Application No: A/201/20/DOC
Site Address: Land South of Water Lane Angmering
Description of works: Approval of details reserved by condition imposed under ref A/99/17/OUT relating to Condition Nos 11 - highways, 12 - refuse & recycling bins, 13 - parking, 15 - fire hydrants, 29 - contamination, 31 - verification report, 32 - electric vehicle charging strategy and 33 - external lighting

The following comments are provided on the proposed lighting scheme, in consultation with the SDNPA Dark Night Skies officer.

**RESERVED MATTERS
GENERAL ARRANGEMENT
SHEET 2**

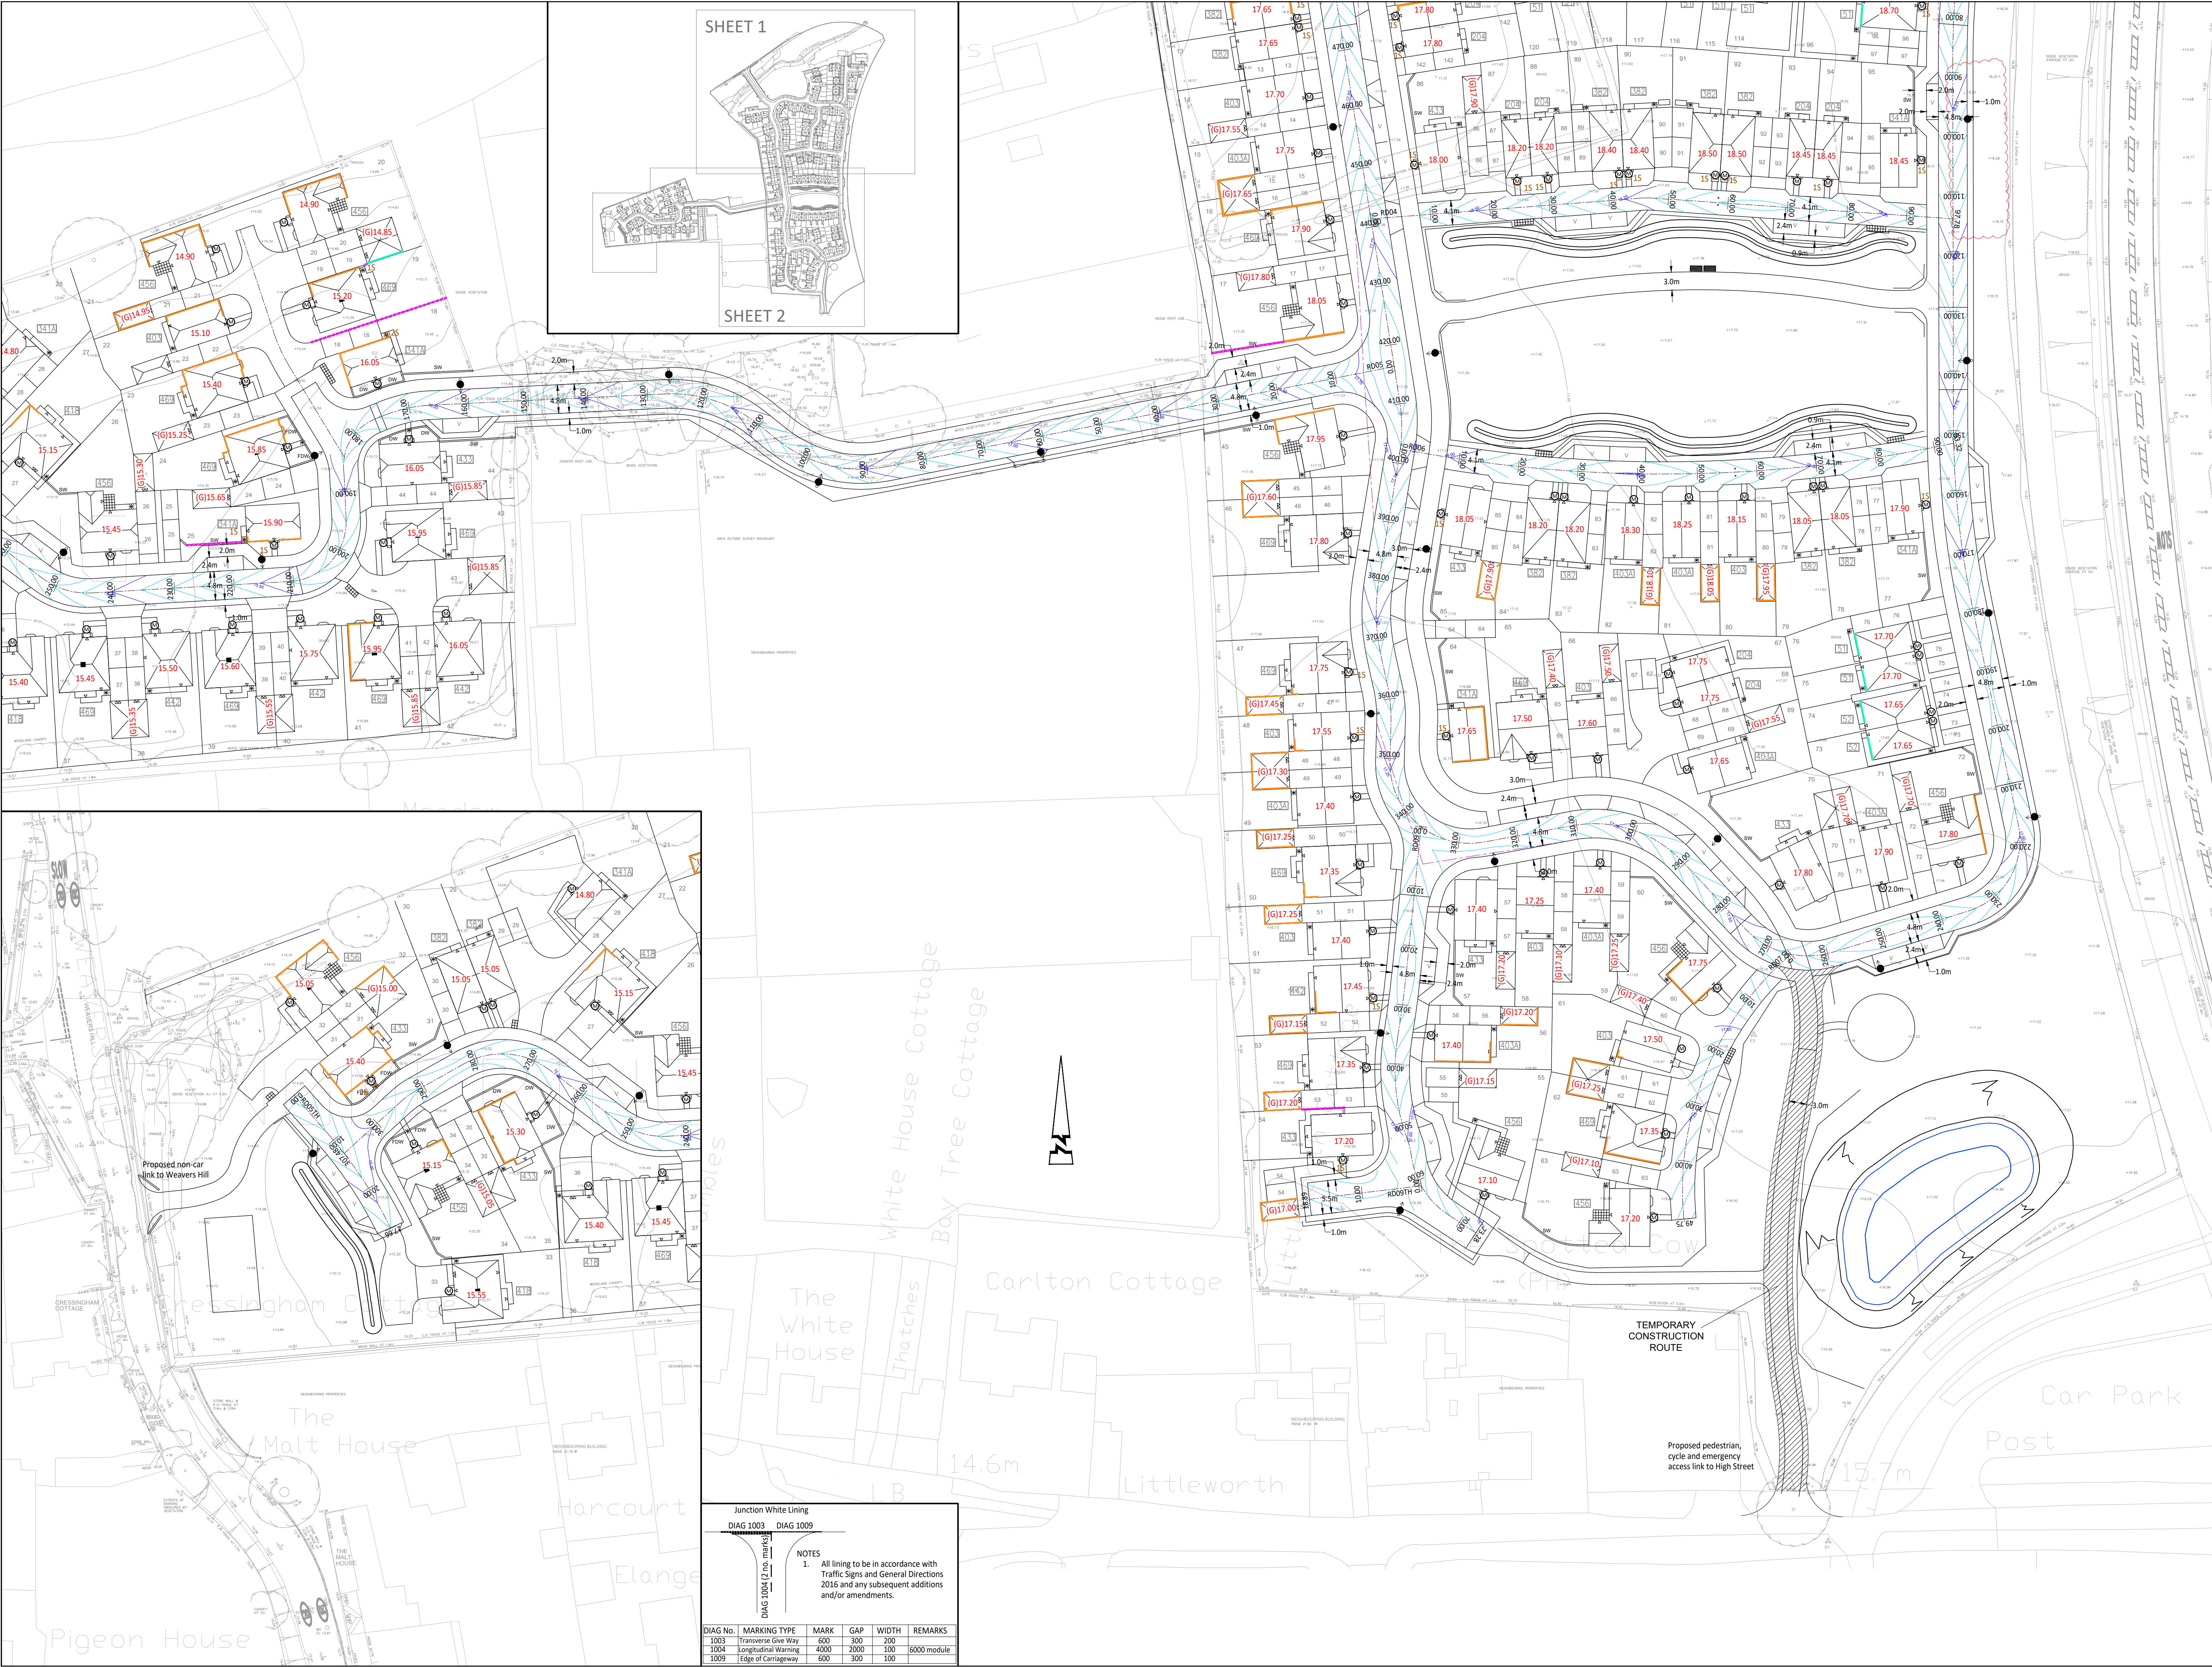
consistent with lighting elsewhere. However, instead of the standard default to long columns low level bollards would assist in reducing harmful sky glow.
